East Anglia ONE North and East Anglia TWO Offshore Windfarms

Applicants' Comments on East Suffolk Council's Deadline 5 Submissions

Applicant: East Anglia TWO and East Anglia ONE North Limited
Document Reference: ExA.AS-19.D6.V1
SPR Reference: EA1N_EA2-DWF-ENV-REP-IBR-001247

Date: 24th February 2021
Revision: Version 1
Author: Royal HaskoningDHV

Outline Landscape Mitigation Plan

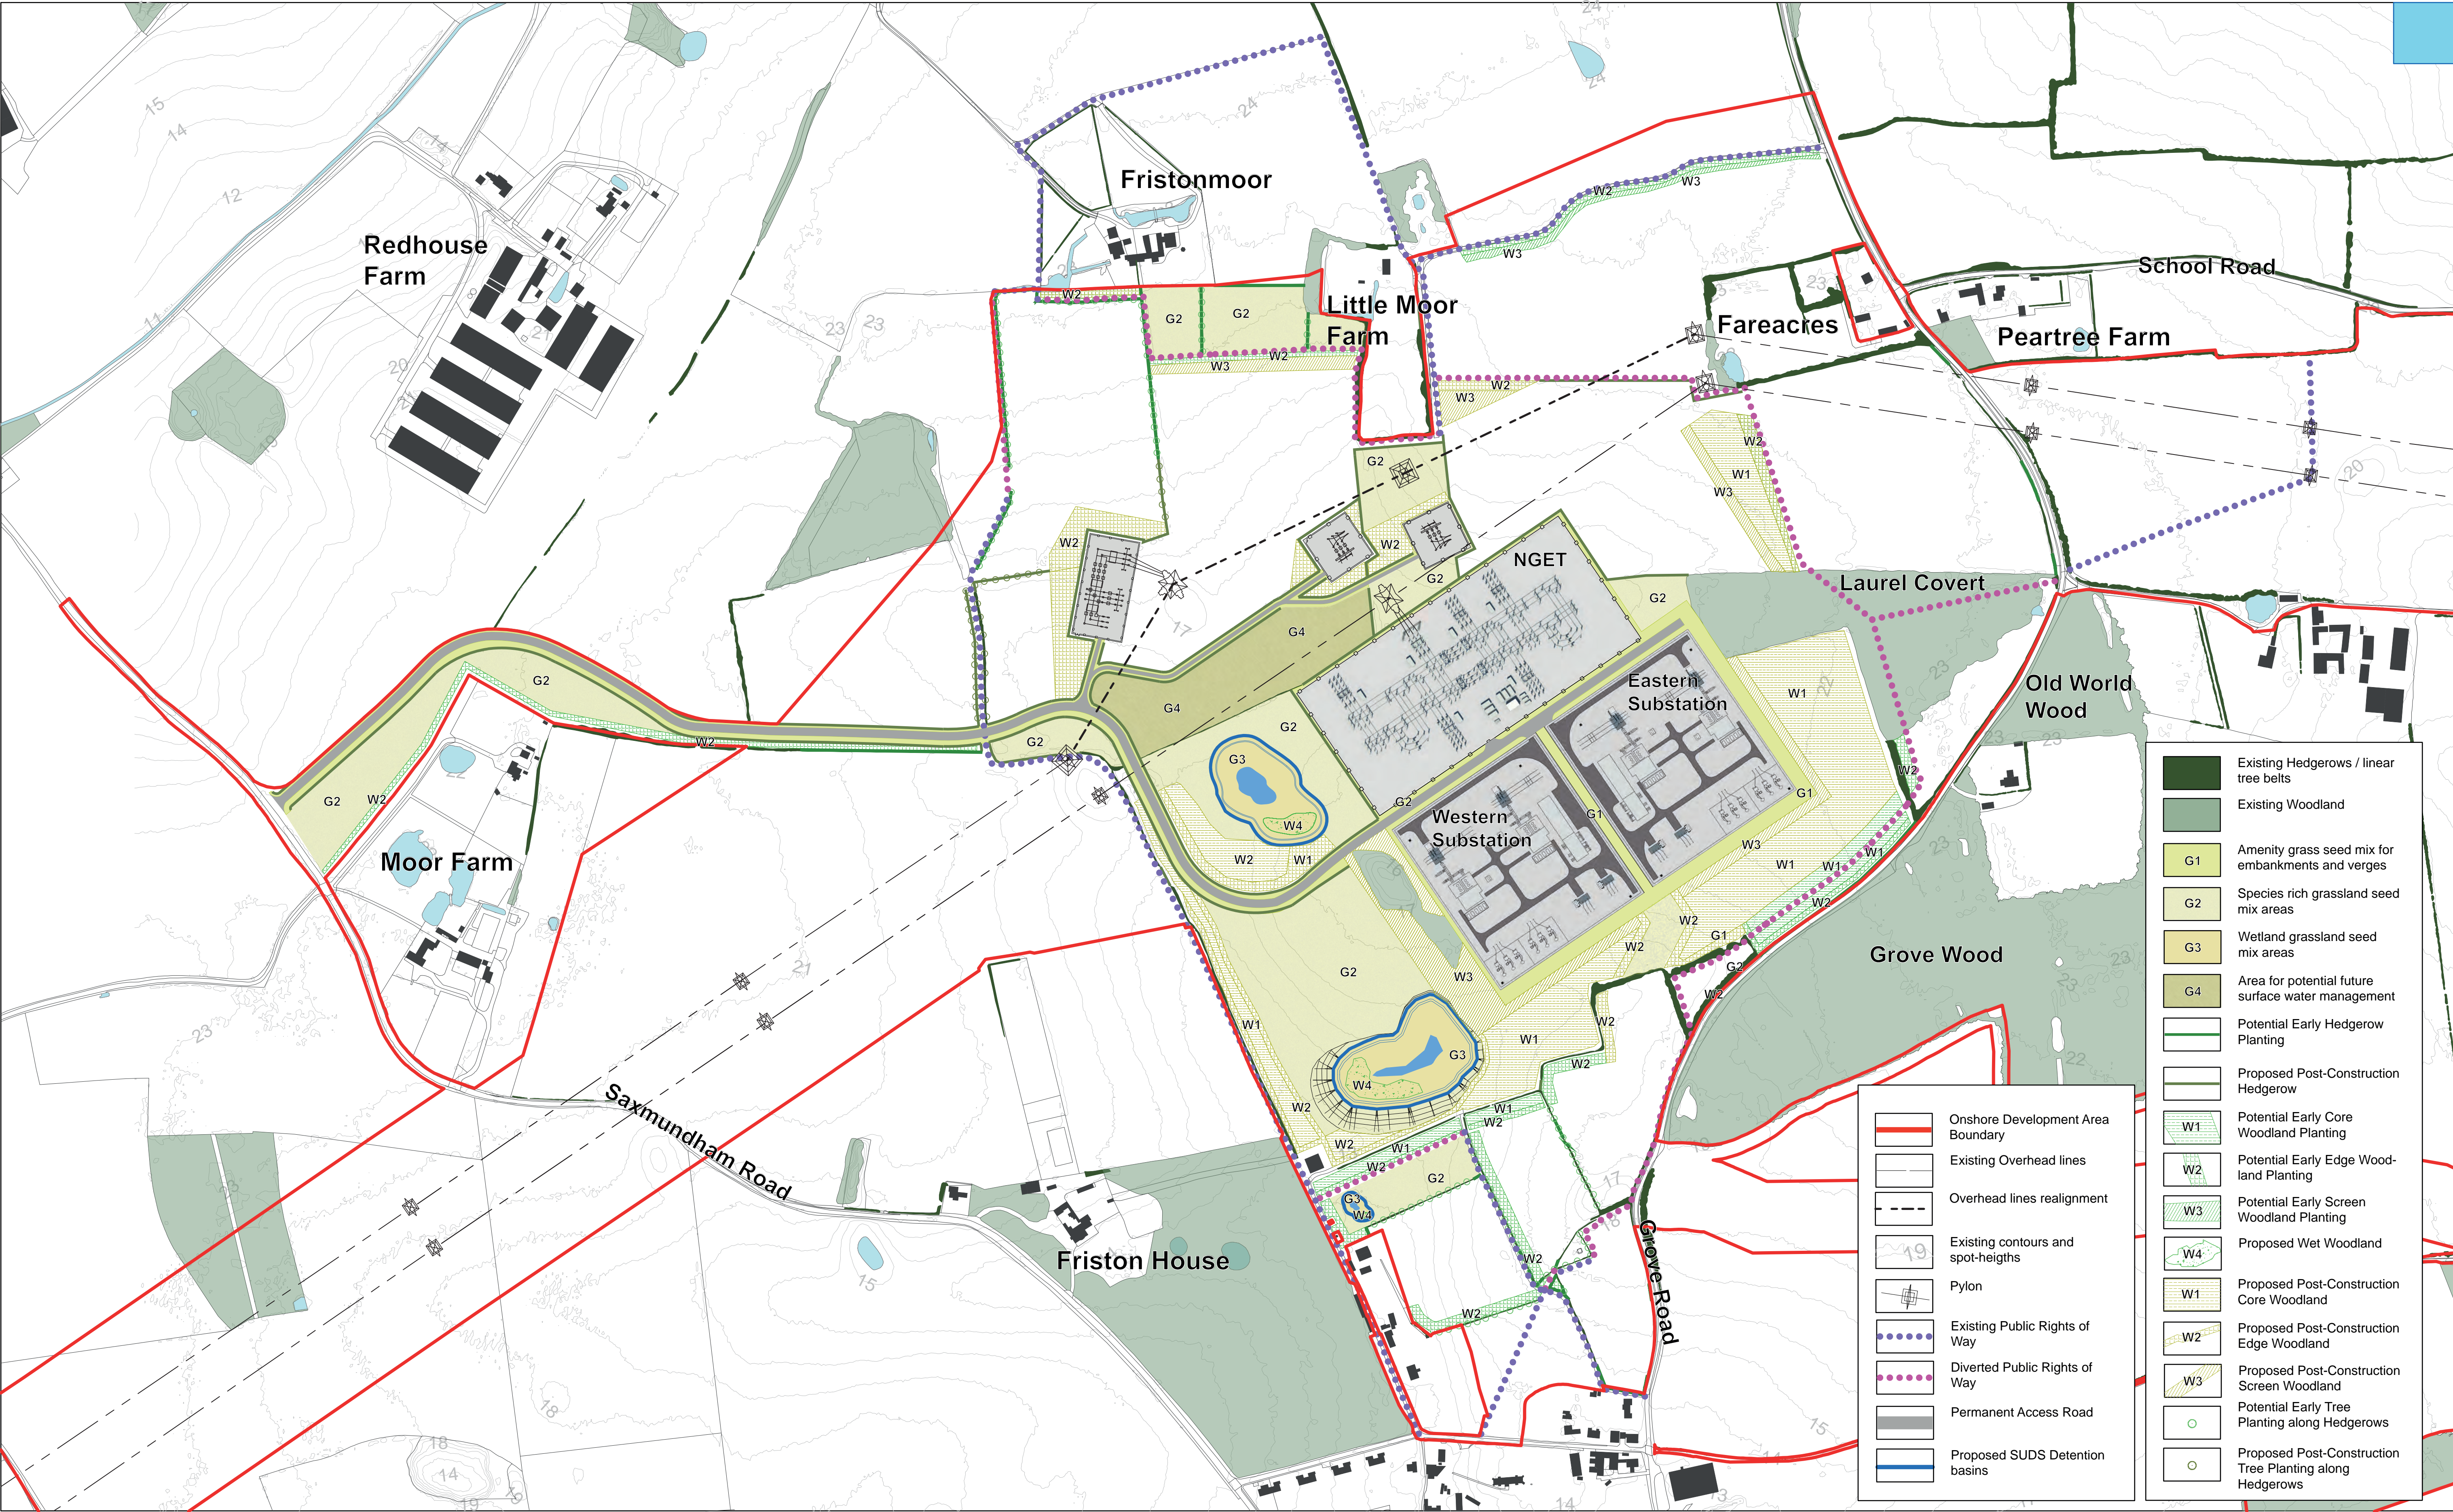
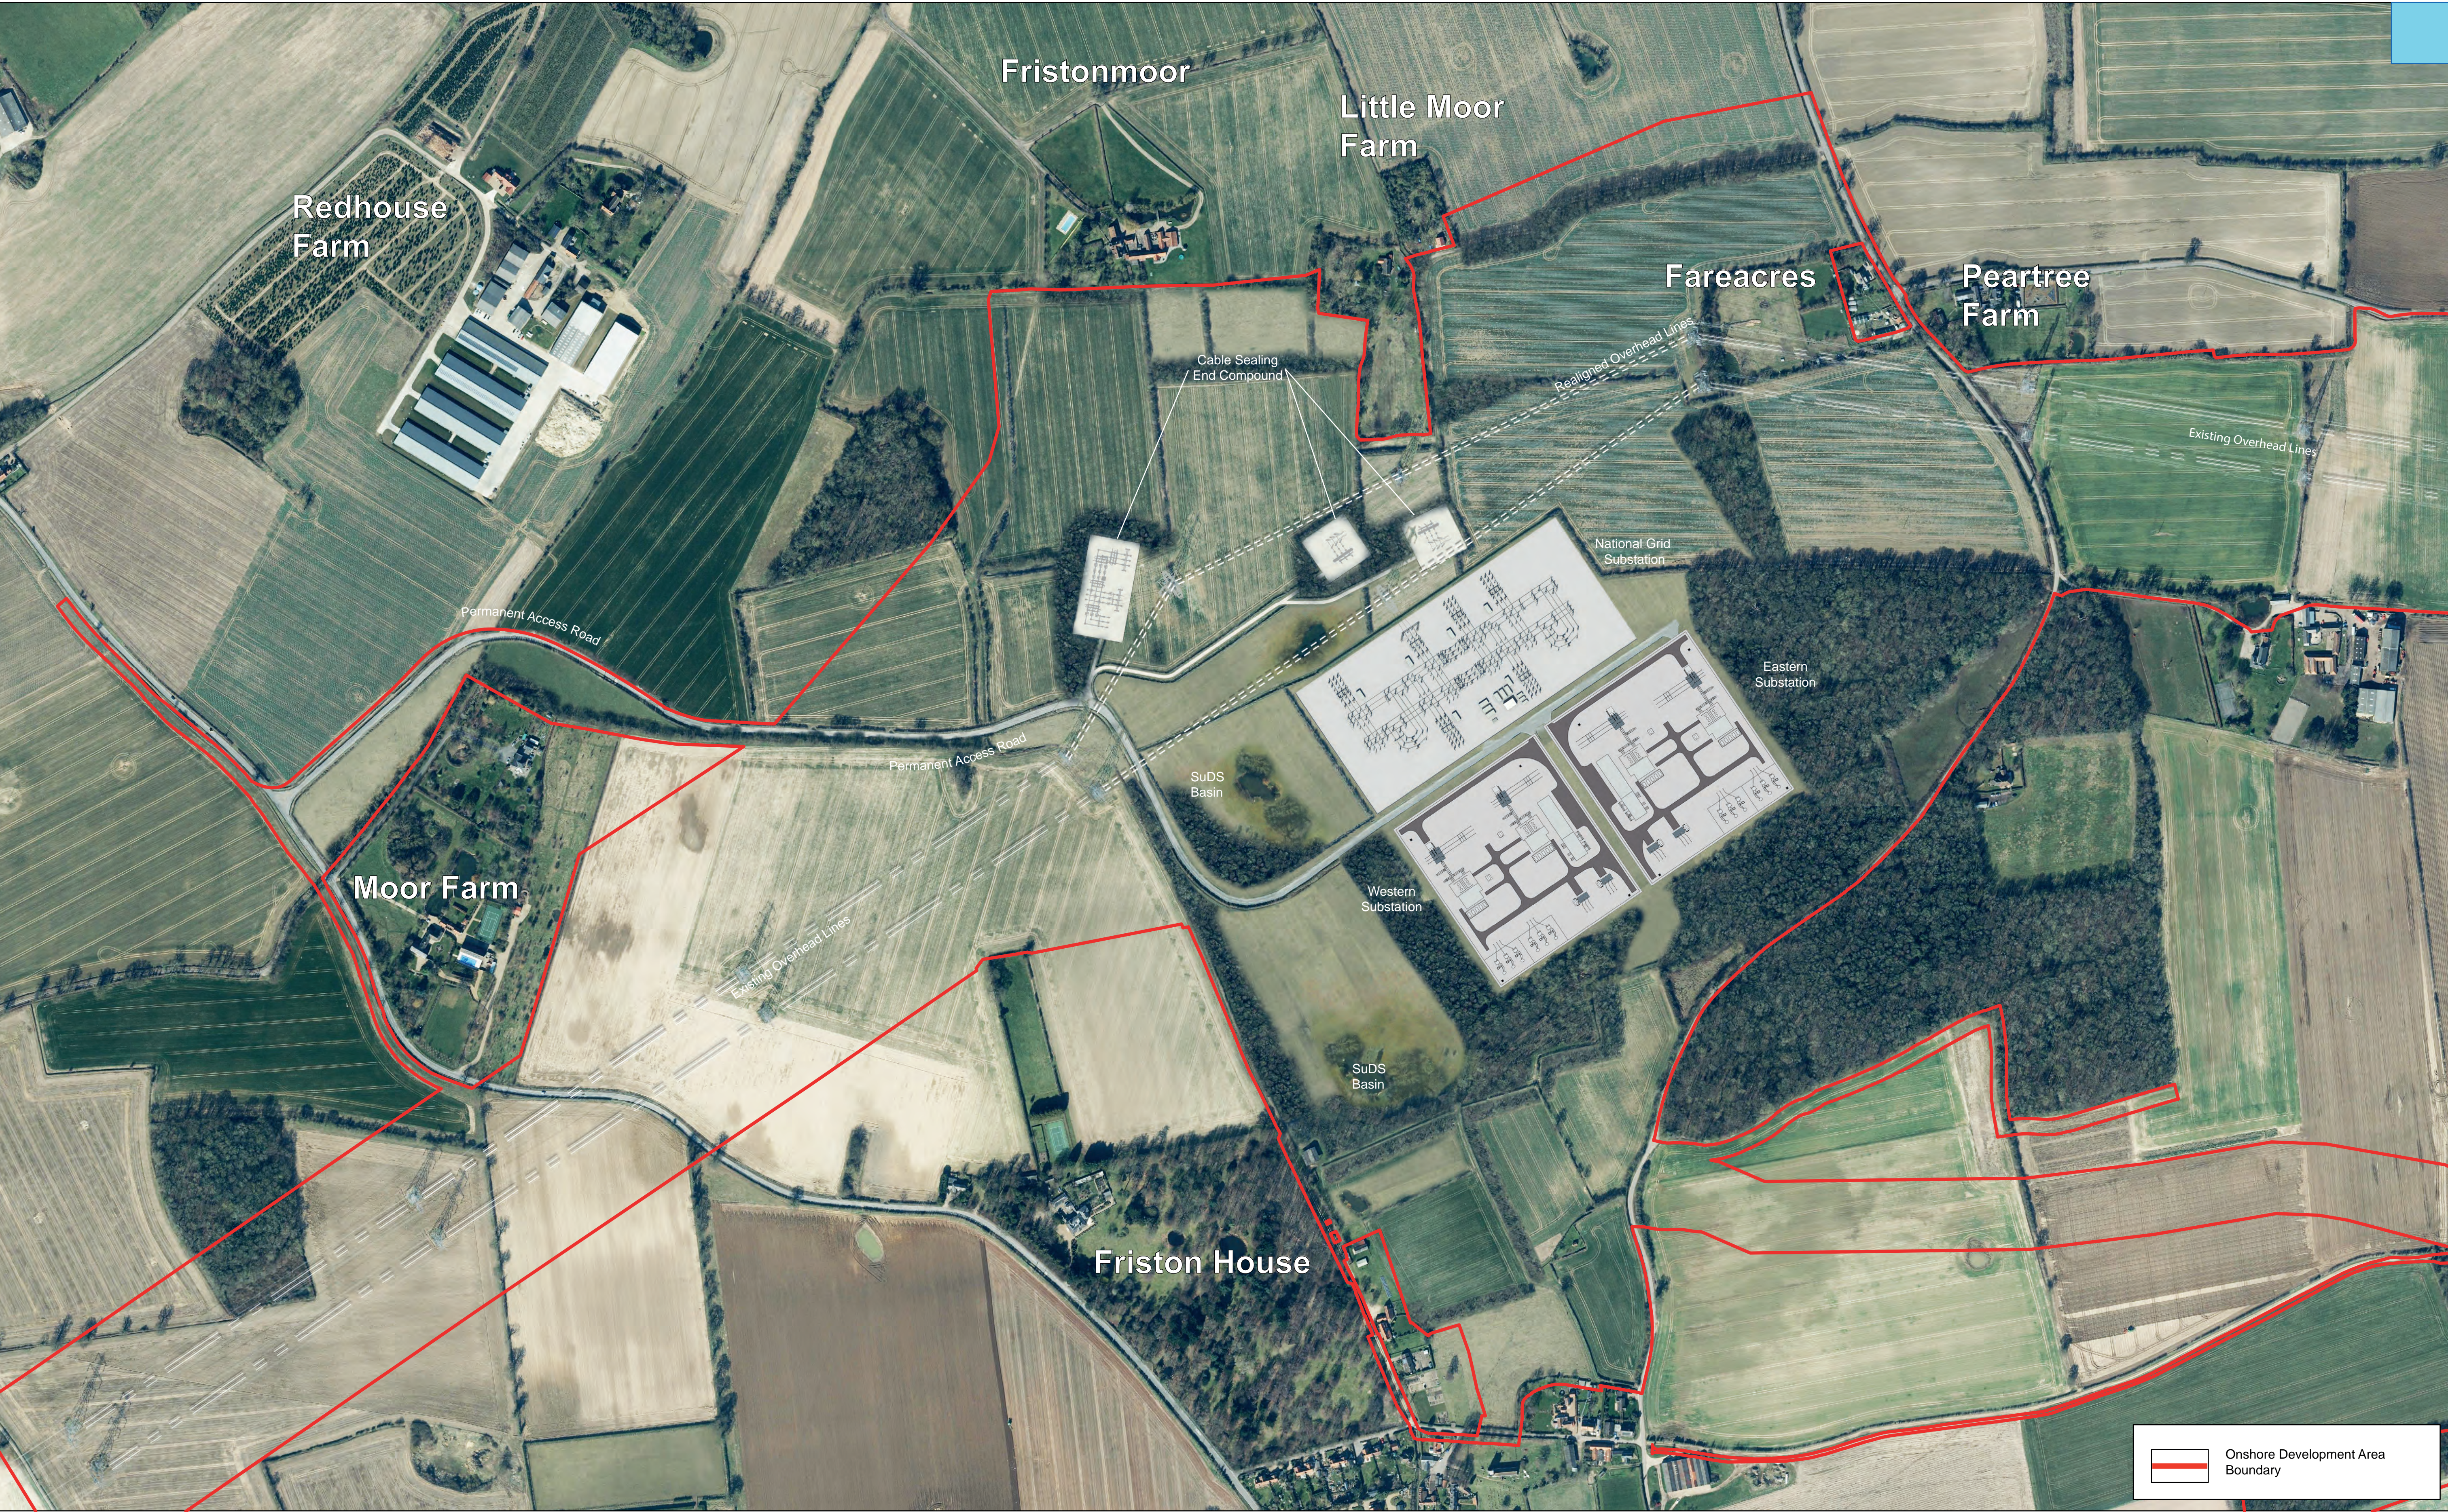
ID	ESC's Deadline 5 Comment	Applicants' Response
1	<p>The various new planting layout proposals are noted and accepted as an improvement on previous versions. The retention of existing tree cover to the west of the substations site is welcomed as is the newly proposed planting around the sealing end compounds and to the south of Little Moor Farm (as also noted in Paragraph 23 of Deadline 4 Project Update Note – REP4-026).</p> <p>ESC remains disappointed that National Grid have not engaged with their supply chains to see if the footprints and heights of their substation infrastructure could be reduced.</p> <p>ESC welcomes the inclusion of the sealing end compounds within the scope of Requirement 12 of the DCOs. It is considered that relatively minor modifications to the siting of the infrastructure would allow the retention of existing field boundaries which would be beneficial.</p>	<p>The Applicants note that ESC welcomes the updated planting arrangements within the Outline Landscape Mitigation Plan (OLMP) (REP4-013) and the inclusion of sealing end compounds within the scope of Requirement 12 of the draft DCO (REP5-003).</p>
